Our ref: RA/2023/146640/06-L01
Your ref: 2023/93539
Date: 26 October 2025

(AMENDED PLANS/DOCUMENTS SUBMITTED) OUTLINE APPLICATION, INCLUDING THE CONSIDERATIONS OF ACCESS APPEARANCE, LAYOUT, AND SCALE, FOR THE ERECTION OF A SIX-STOREY BUILDING TO HOST 76 RESIDENTIAL APARTMENTS (C3 USE) AND ANCILLARY WORKS COMPRISING DEMOLITION OF VACANT BUILDING, FORMATION OF NEW ACCESS, PARKING AREAS, OPEN SPACE AND LANDSCAPING; ERECTION OF CYCLE AND BIN REFUSE STORAGE STRUCTURES

AT LAND ADJACENT TO LEDGARD BRIDGE MILL, BACK STATION ROAD, MIRFIELD, KIRKLEES, WEST YORKSHIRE WF14 8NZ

Environment Agency position – Flood Risk

Opening formed in bridge parapet at junction between flat and saddle copings - see also photographs - with landing structure formed in walkway to create waiting area.

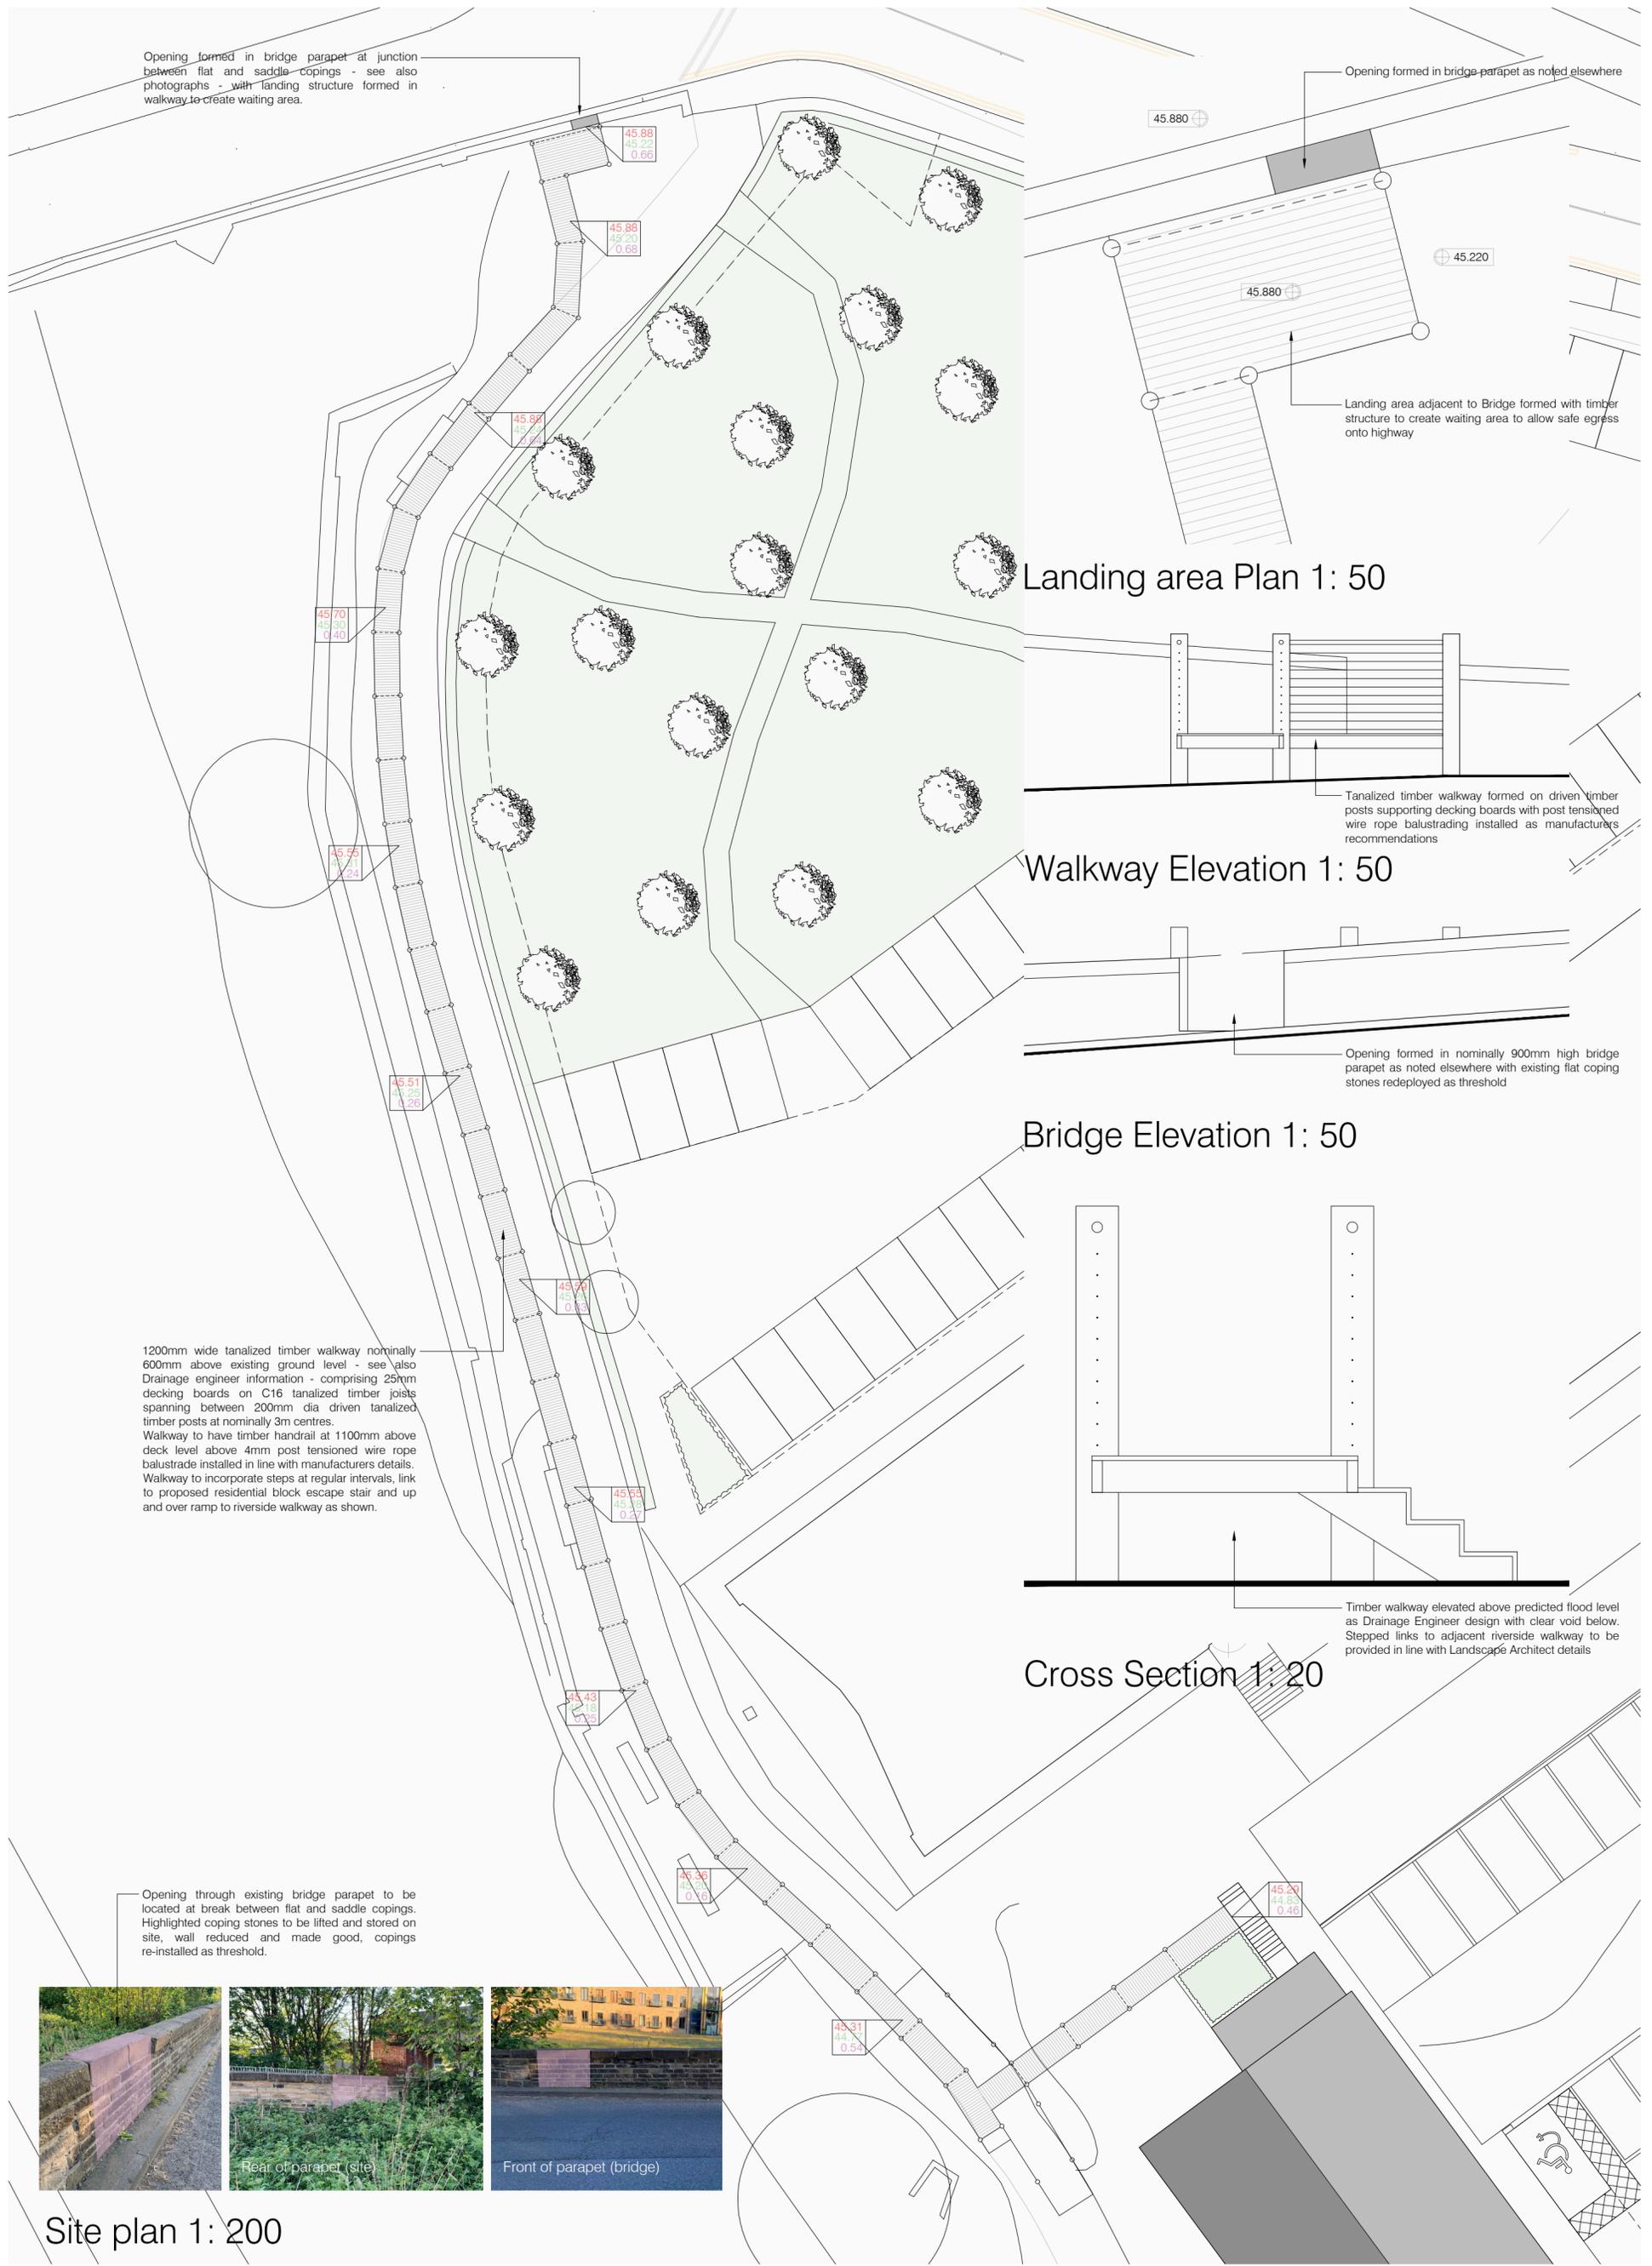
- Finished floor levels shall be no lower than 45.68 metres Above Ordnance Datum (AOD)
- The proposed buildings shall be built on voids. The soffit of the void should be set to a minimum elevation of 45.68mAOD
- An elevated walkway shall be constructed from the proposed building to the bridge abutment.
